BOTLEY WEST SOLAR FARM
PLANNING ACT 2008
INFRASTRUCTURE PLANNING (APPLICATIONS: PRESCRIBED FORMS AND
PROCEDURE) REGULATIONS 2009

SBW's WRITTEN SUBMISSIONS FOR DEADLINE 7

Deadline 7 Submissions

10 November 2025

## Appendix 4: Figure 2.1 – 2.4: Location of Bat Hedgerow Buffers

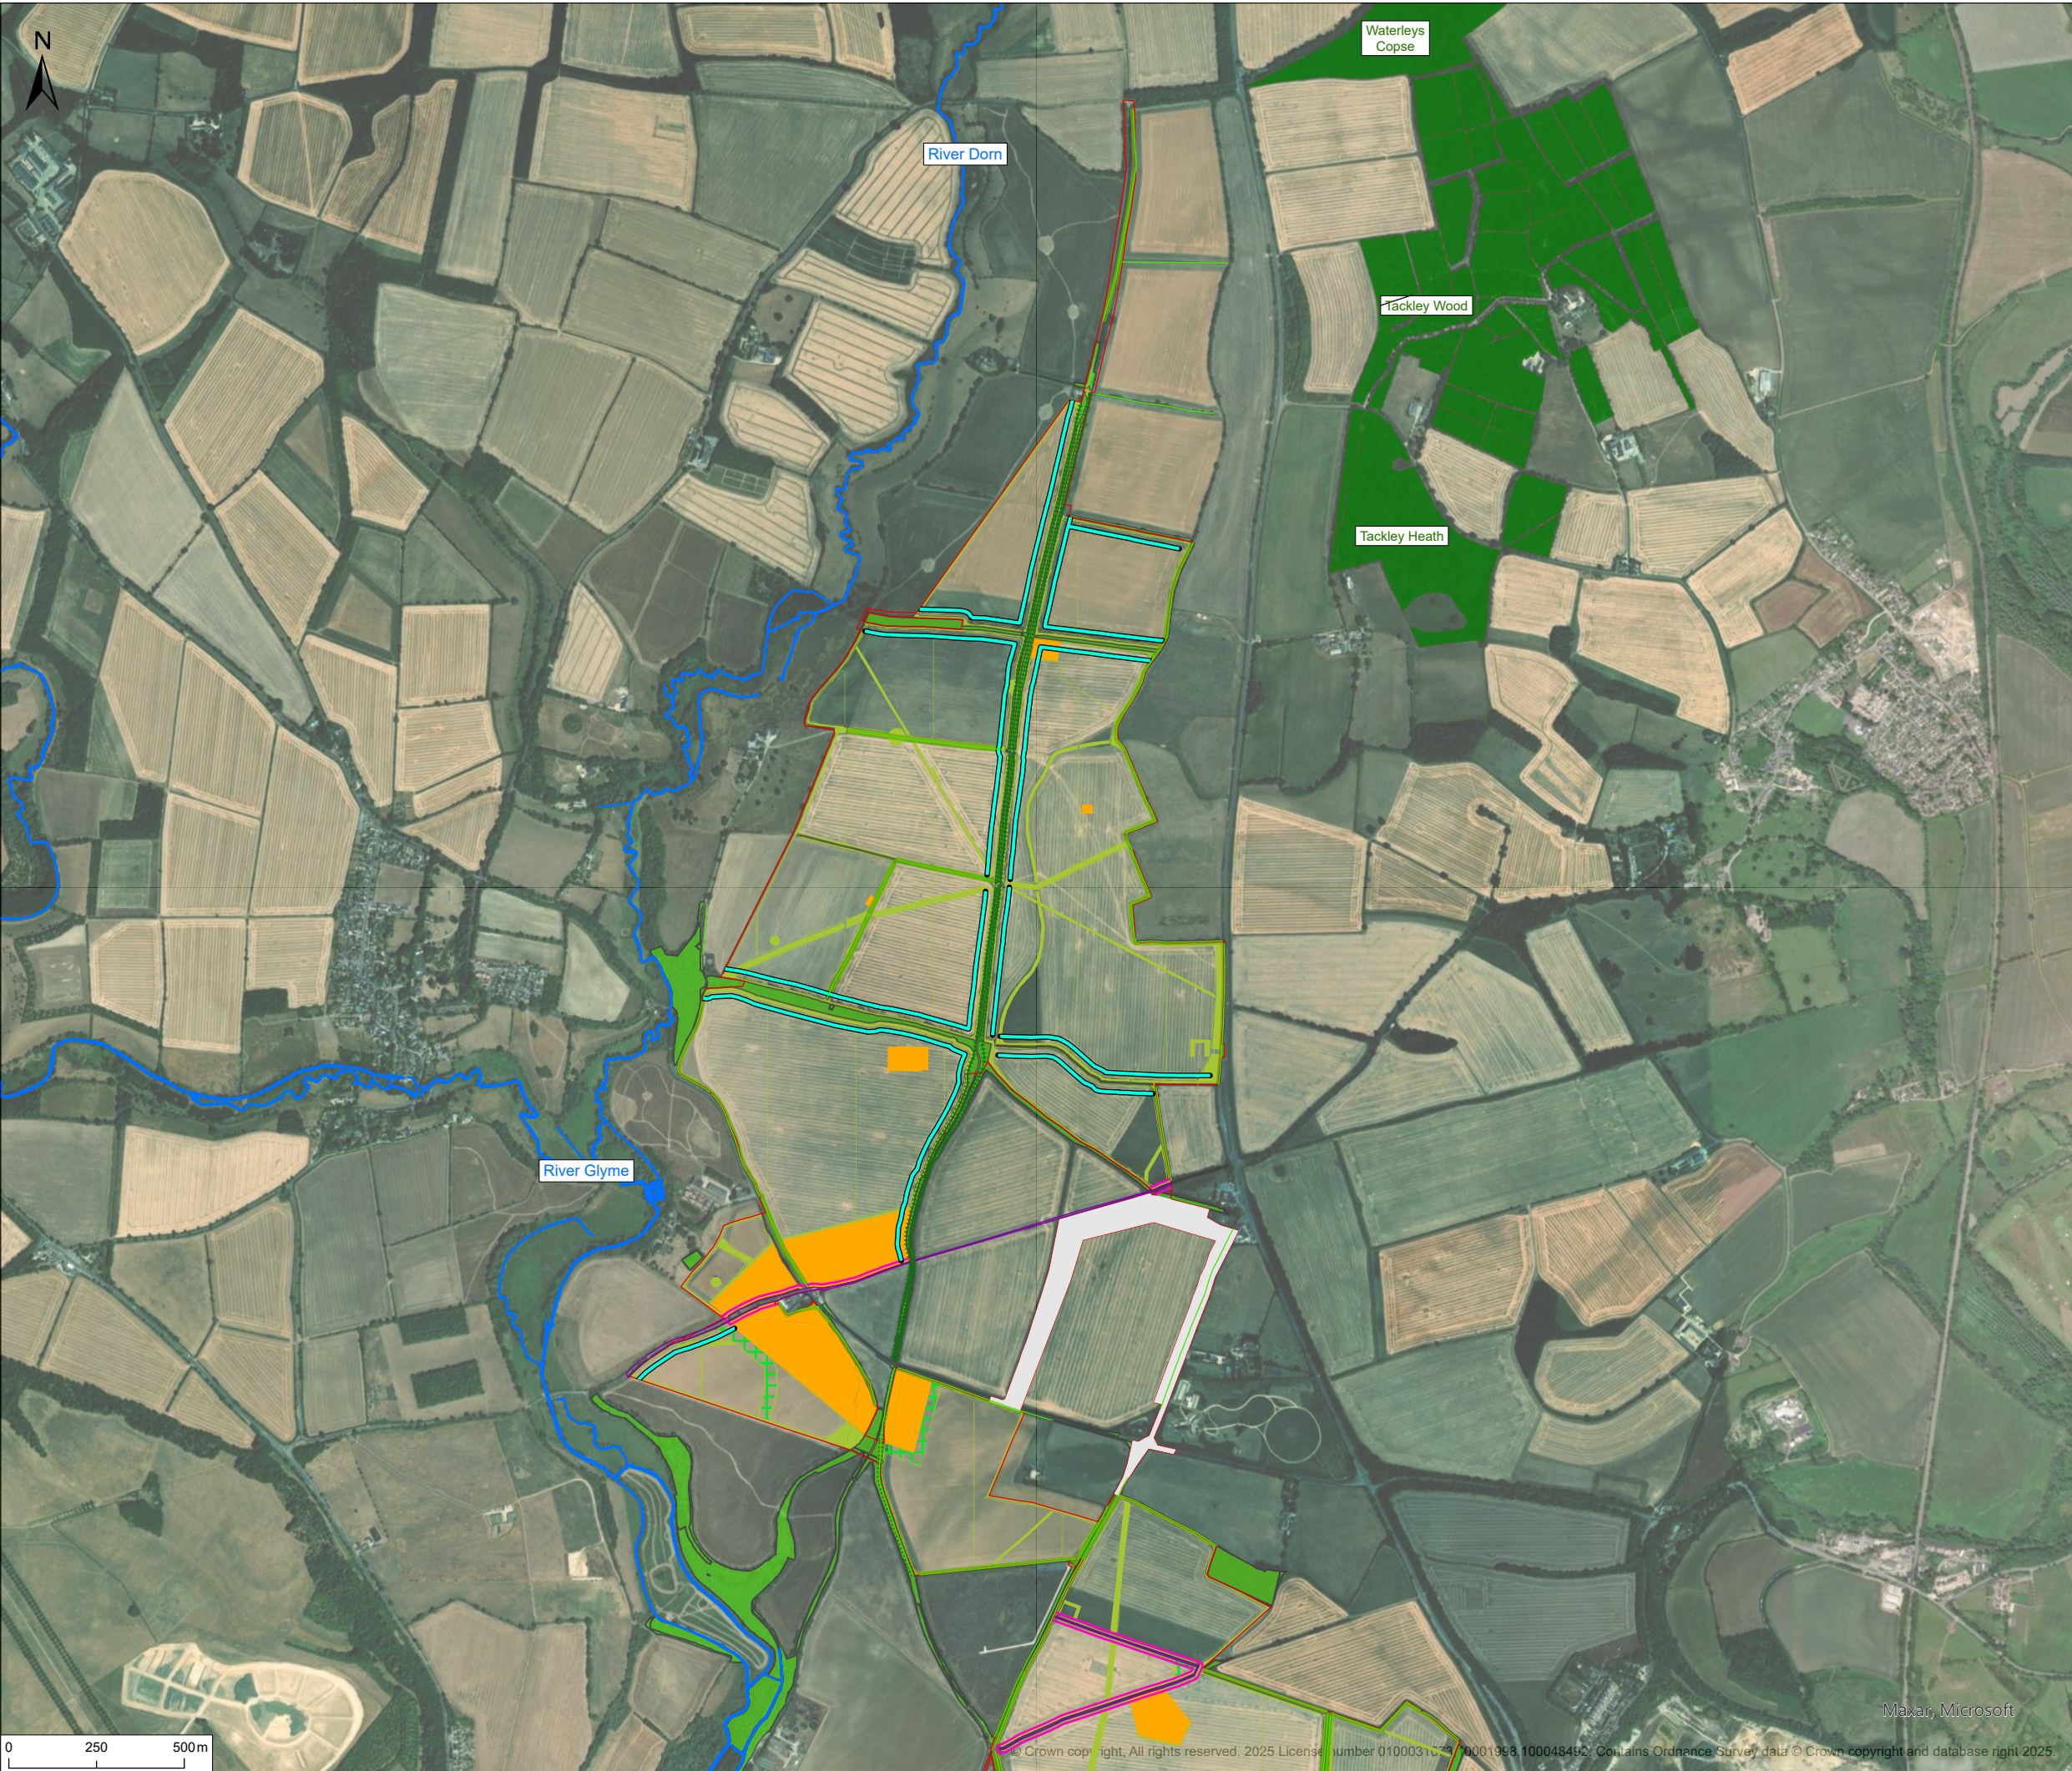
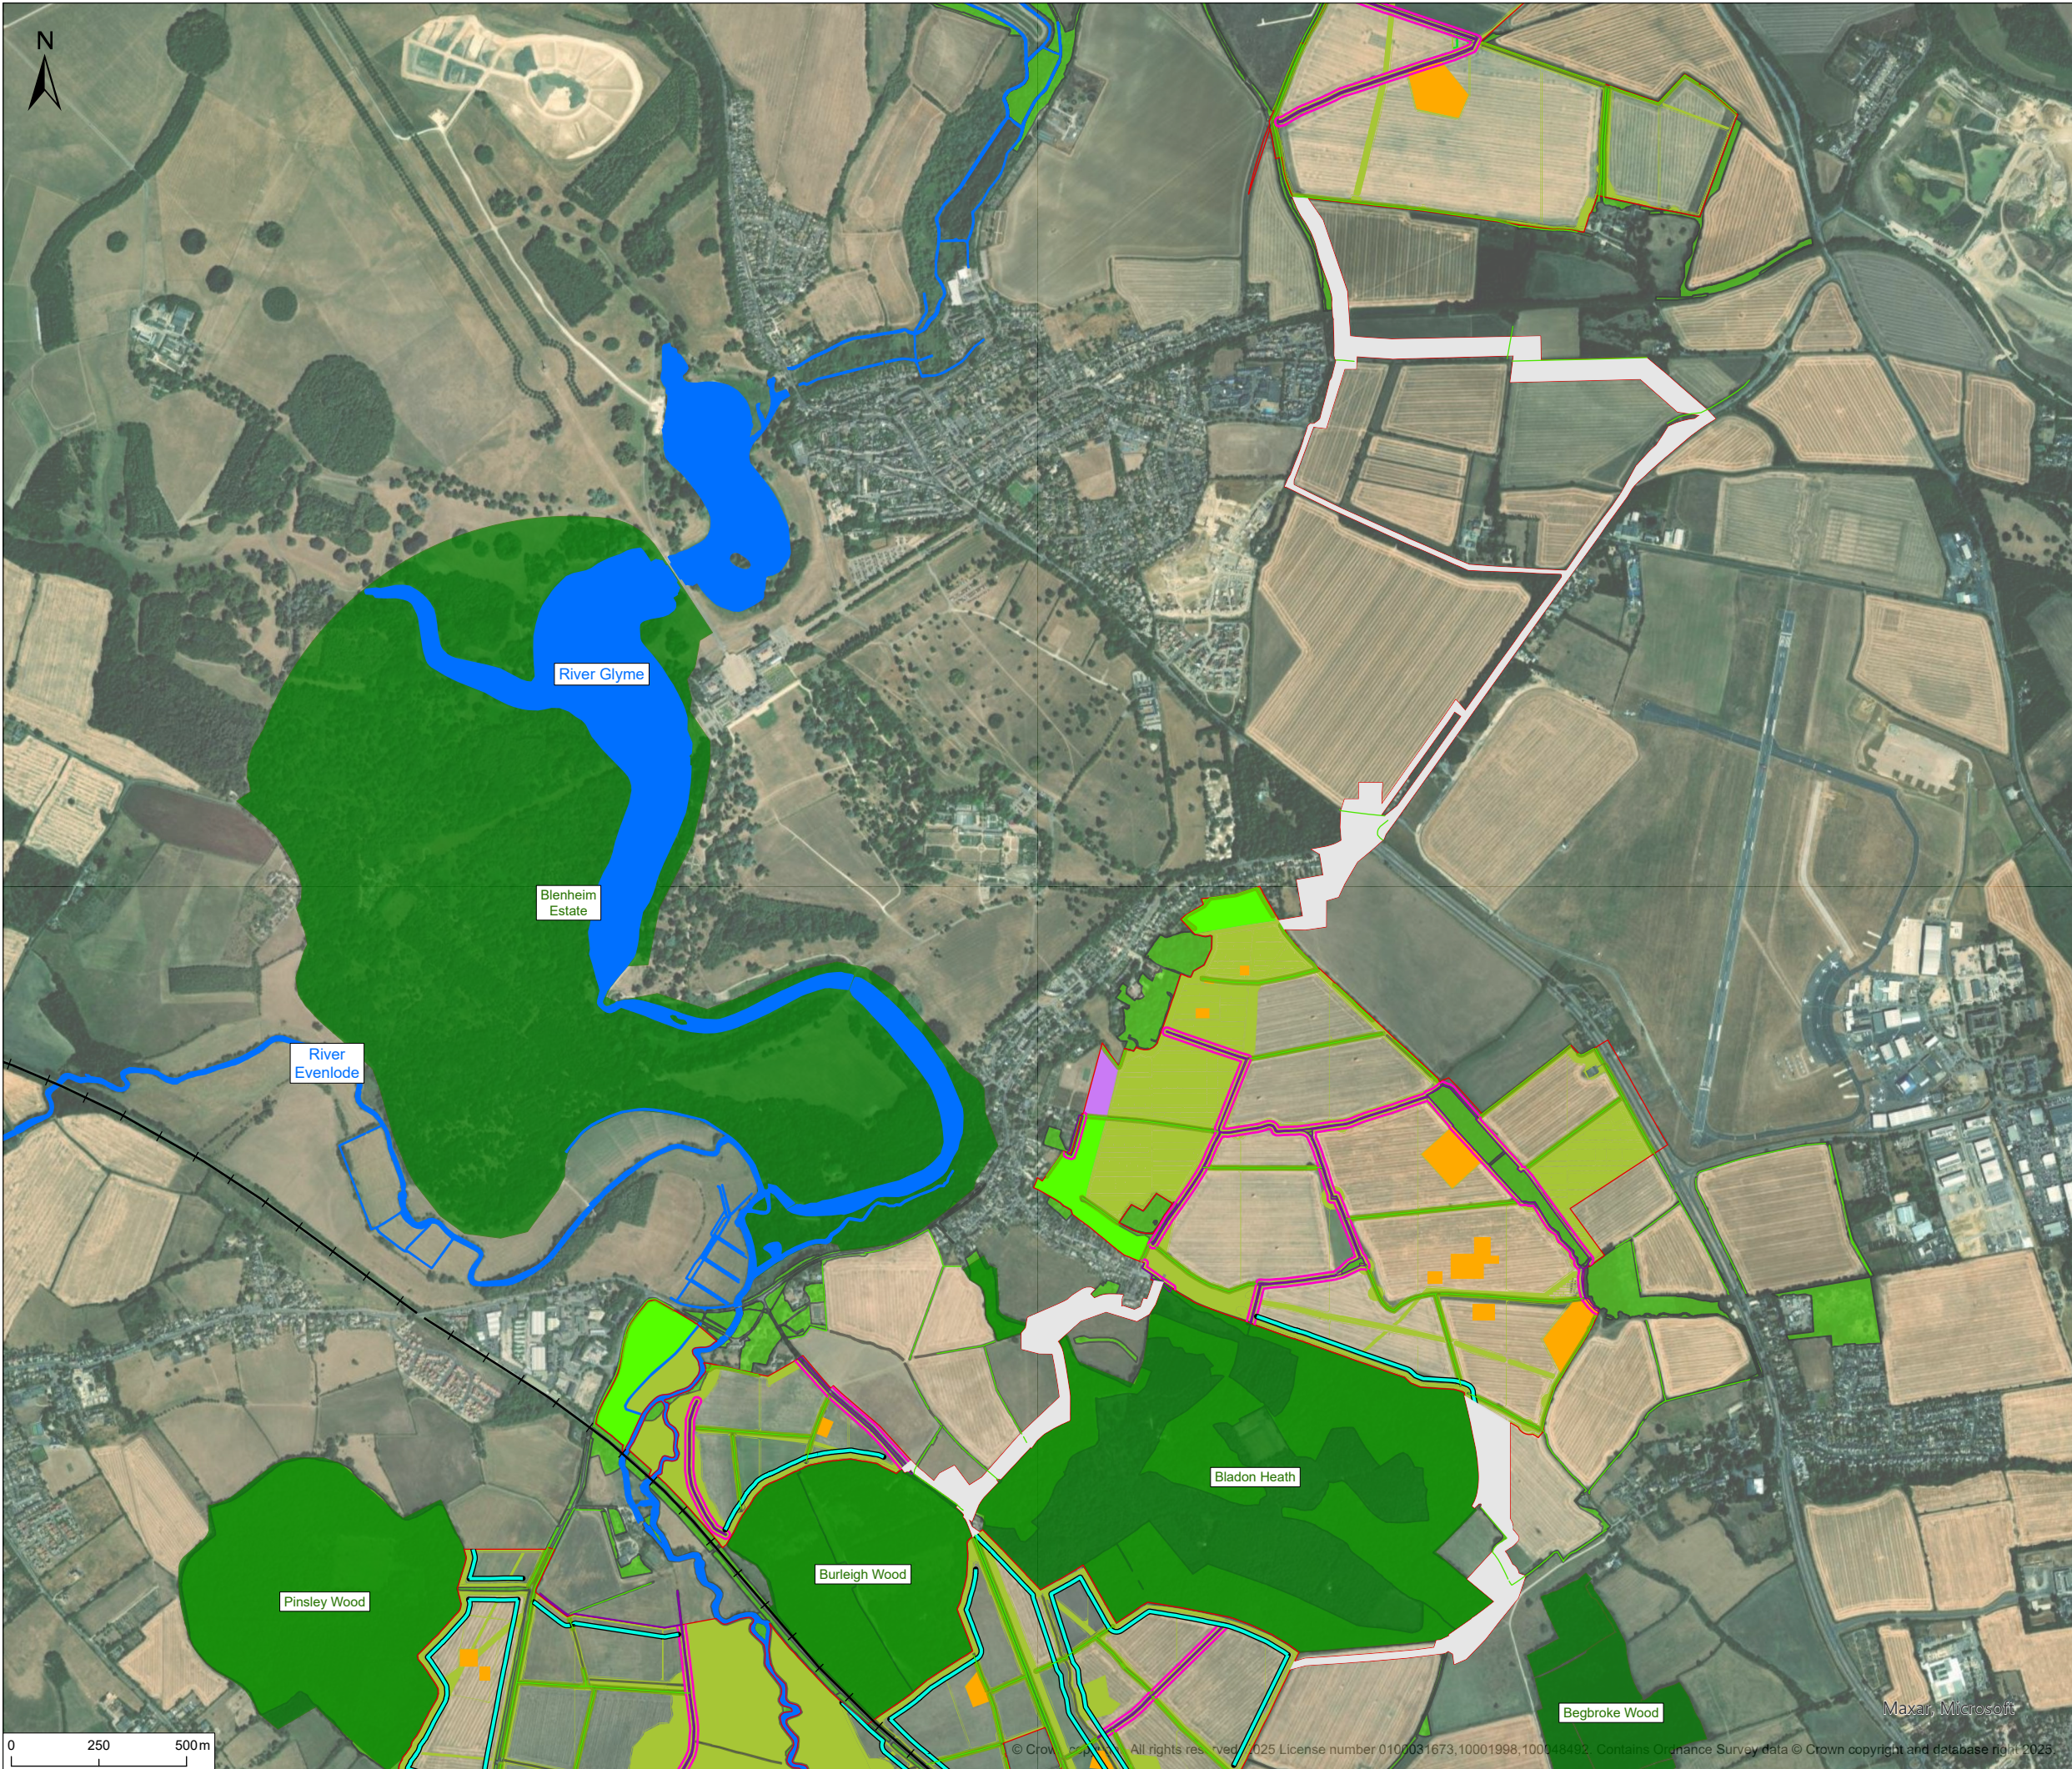
- ii. **Bats.** The Applicant relies on a tiered buffer concept but, as the Host Authorities highlight, Tier A bat flightline buffers are not yet mapped to a level that secures their locations and extents on a plan. The buffers also do not offer any protection for bats that use arable fields for foraging, such as noctules, and thus the outlined strategy will only offer partial protection to bat communities with the Red Line. Monitoring commitments should run for then project lifetime and encompass both flightlines and array areas, yet the Applicant’s proposals remain non-committal and time-limited.
